REFERENCE	DE-2026/21
Date	30 March 2026

EXHIBITION OF STATE SIGNIFICANT DEVELOPMENT APPLICATION
CORRIMAL COKE WORKS – STAGE 2-4 EARLY STAGE (CIVIL WORKS)

Development	State Significant Development - Corrimal Coke Works – Stage 2-4 Early Stage (Civil Works) (SSD-86131212) - Request to Provide Advice on the Environmental Impact Statement (EIS)
Location	Lot 103 DP 1301632 Lots 3, 4 and 8 DP 1313981 Corrimal Cokeworks, Railway Street CORRIMAL NSW 2518

LONGITUDINAL SECTION - RW 03

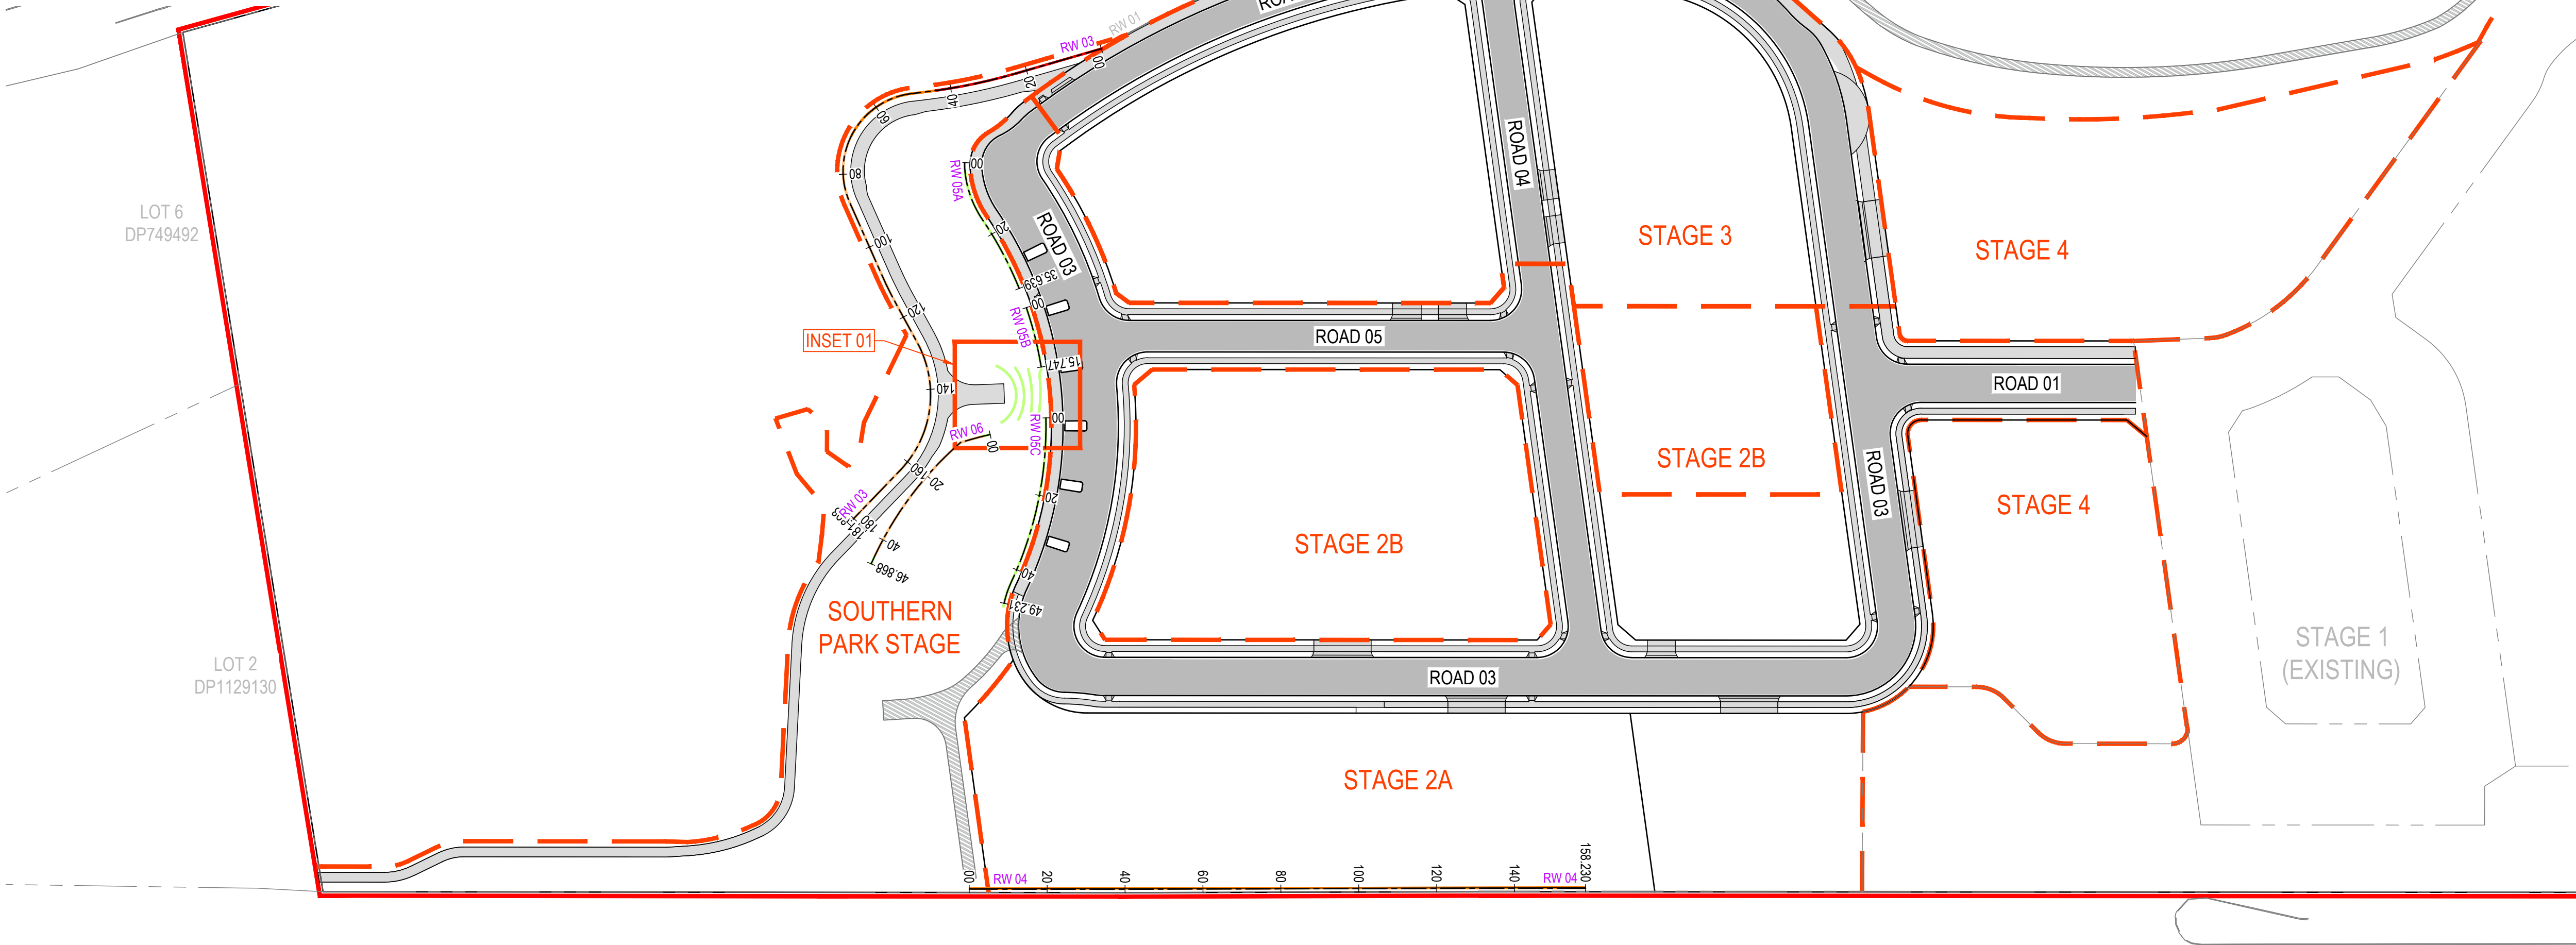
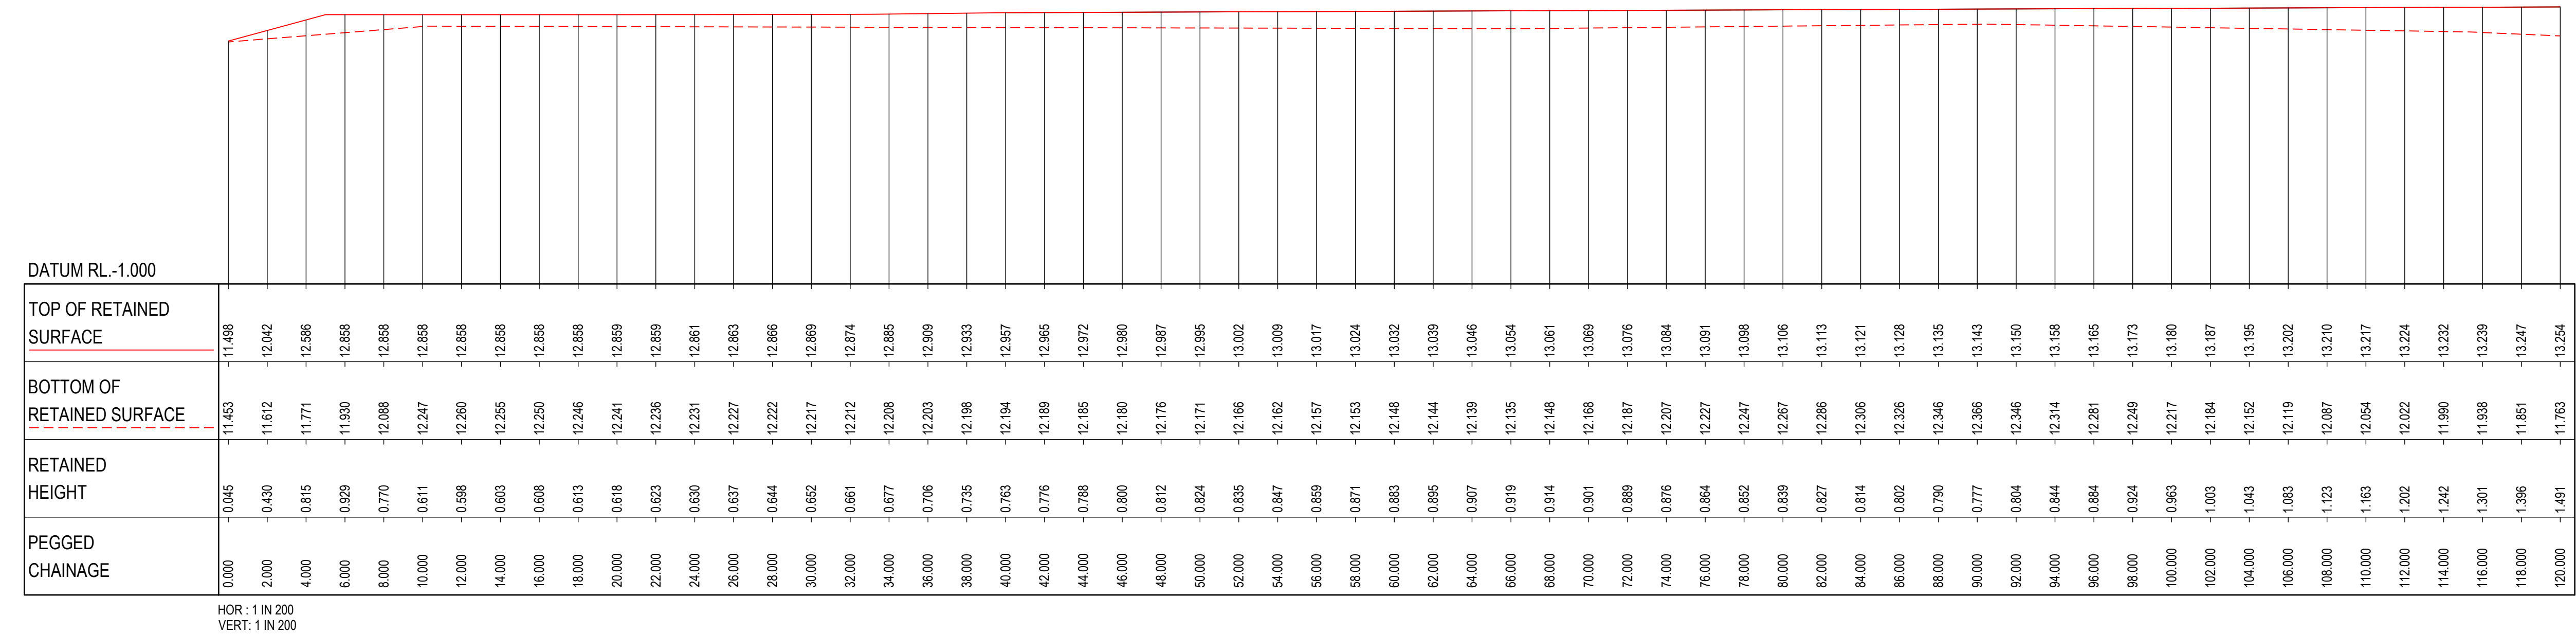
- Submitted civil plans do not document wall heights, materials, or required fencing details for retaining walls adjoining shared paths. Provide full retaining-wall design information, including:
 - wall heights and materials
 - fence types, heights and fixings
 - integration with adjacent pathways, levels and drainage
 - compliance with relevant Australian Standards.
- Southern Park Amphitheatre – Design Conflict. There is a significant conflict between:
 - the proposed concrete vehicle turning head (refuse/maintenance/emergency), and
 - the intended amphitheatre public-realm function (tiered seating, passive recreation, informal landscape finish).
- Further design resolution is required demonstrating:
 - how vehicular infrastructure is integrated without compromising public-realm quality,
